Our Ref: 20/00909/HOU
Your Ref: REAR SINGLE
STOREY EXTENSION

LOCATION: 84 Hartley Road, Portsmouth, PO2 9HX, ,

PROPOSAL: Single storey flat roof rear extension **(20/00909/HOU)**

Proposed Layout Extension, Alterations & Improvements

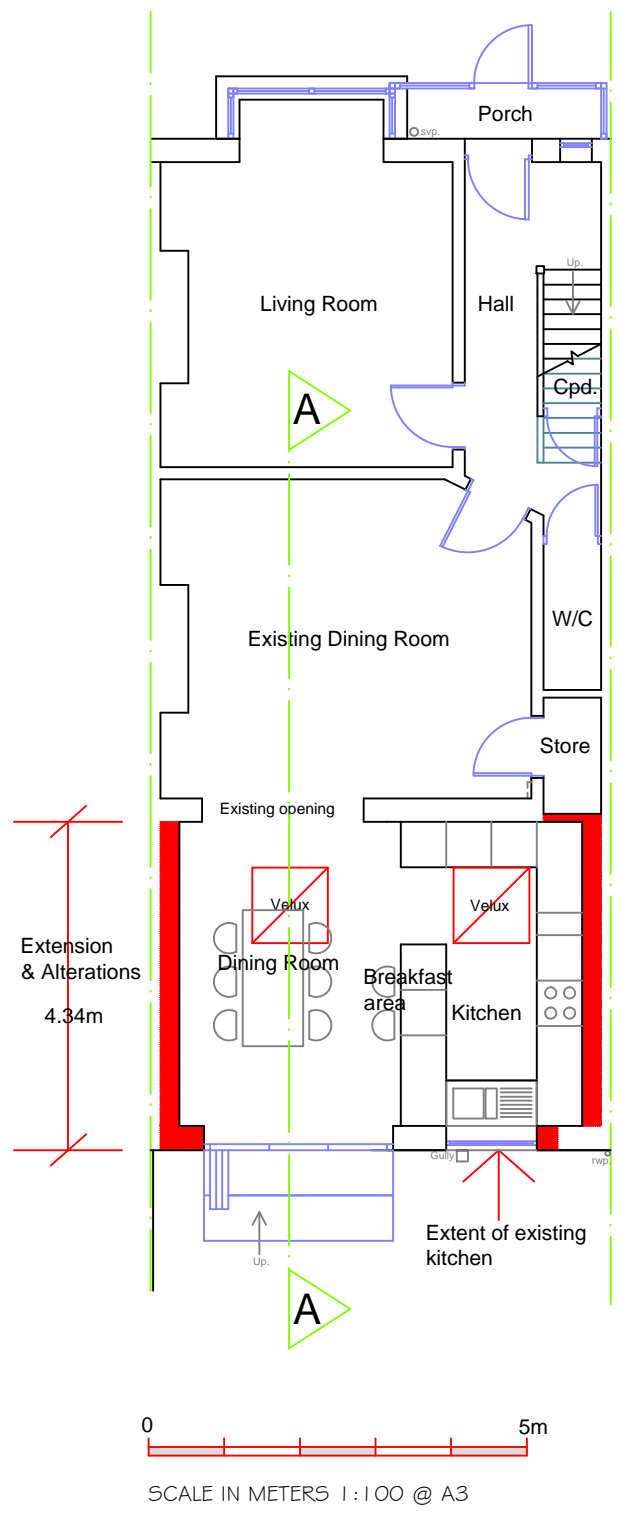
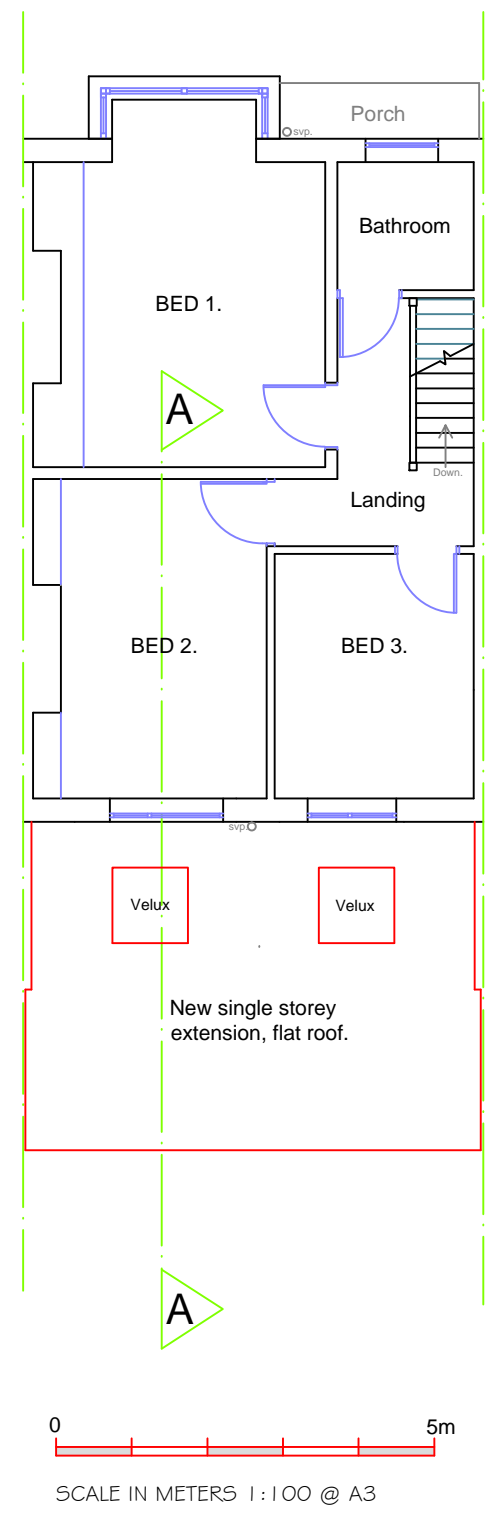
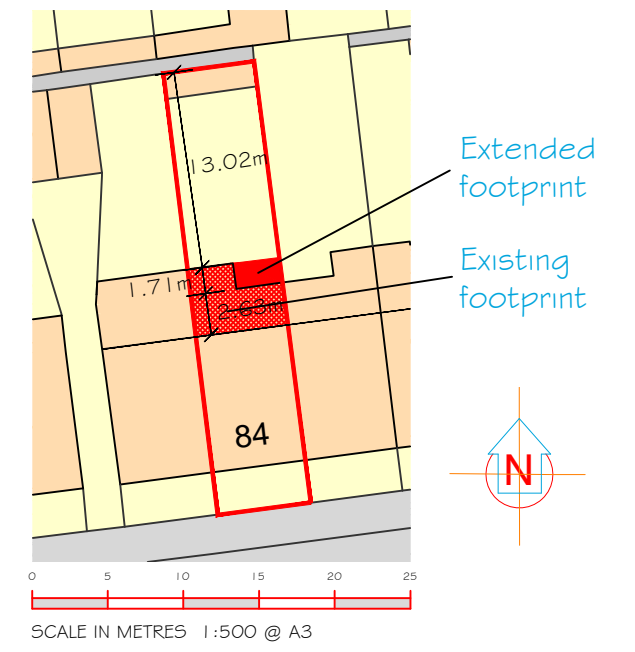
- 1) Both side elevations required for existing and proposed plans
